**Consultation Response from KC,
Highways Development Management**

2026/90893 84, York Avenue, Fartown, Huddersfield, 2026/90893

Erection of ground floor wrap around and first floor side extensions

Site Plan 1.500

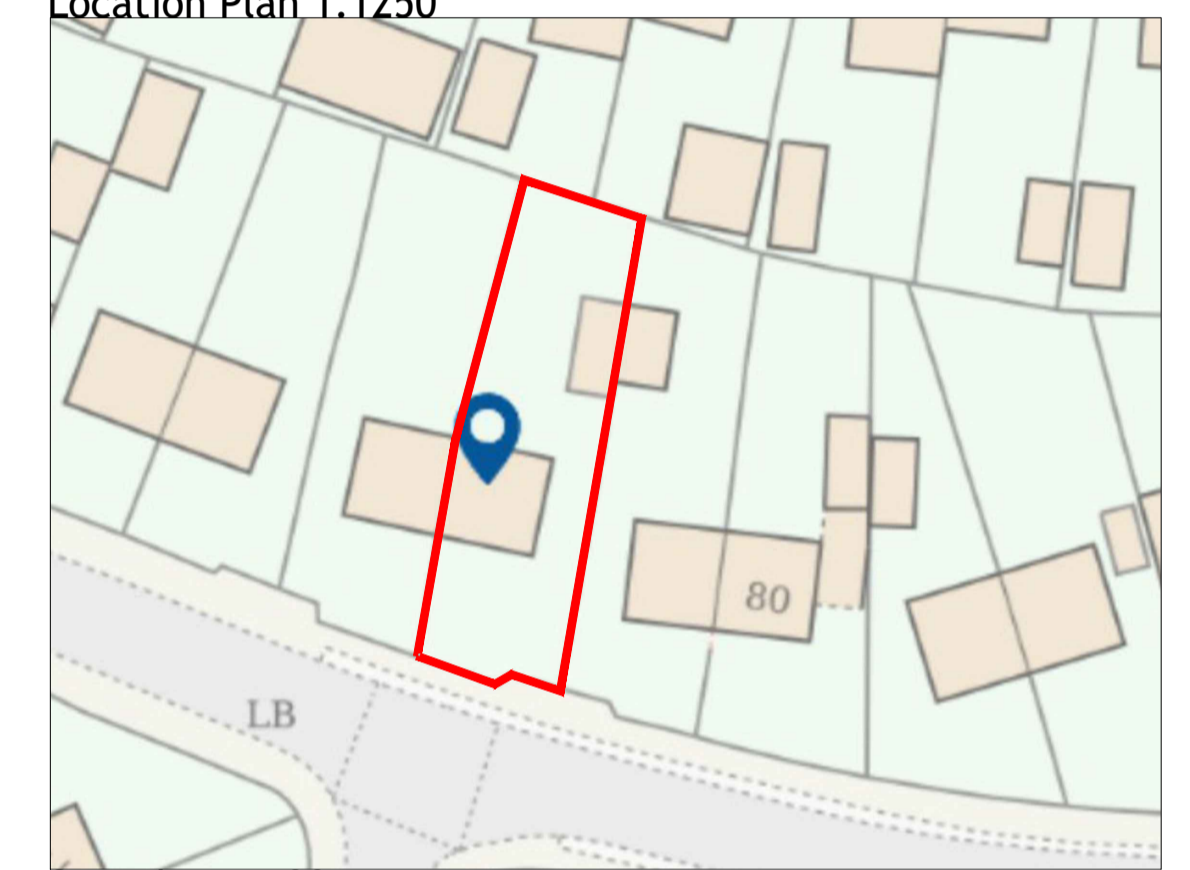
The proposed extensions would retain the existing access but result in the loss of the existing garage and a section of driveway. This reduces the available on-site car parking spaces to two vehicles whilst increasing the number of bedrooms from three to four. Three parking spaces is the advised norm for four bedroomed units under the Kirklees Highway Design Guide SPD. Flexibility is allowed under policy LP 22 and, if the LPA is satisfied that two spaces would be sufficient car parking space after extensions are added, then policy LP 21 would be met for no objection to be raised.

Cycle parking and electric vehicle charging point should be considered to support policy LP20 and mode choice as well as Active Travel objectives in the case of cycles.
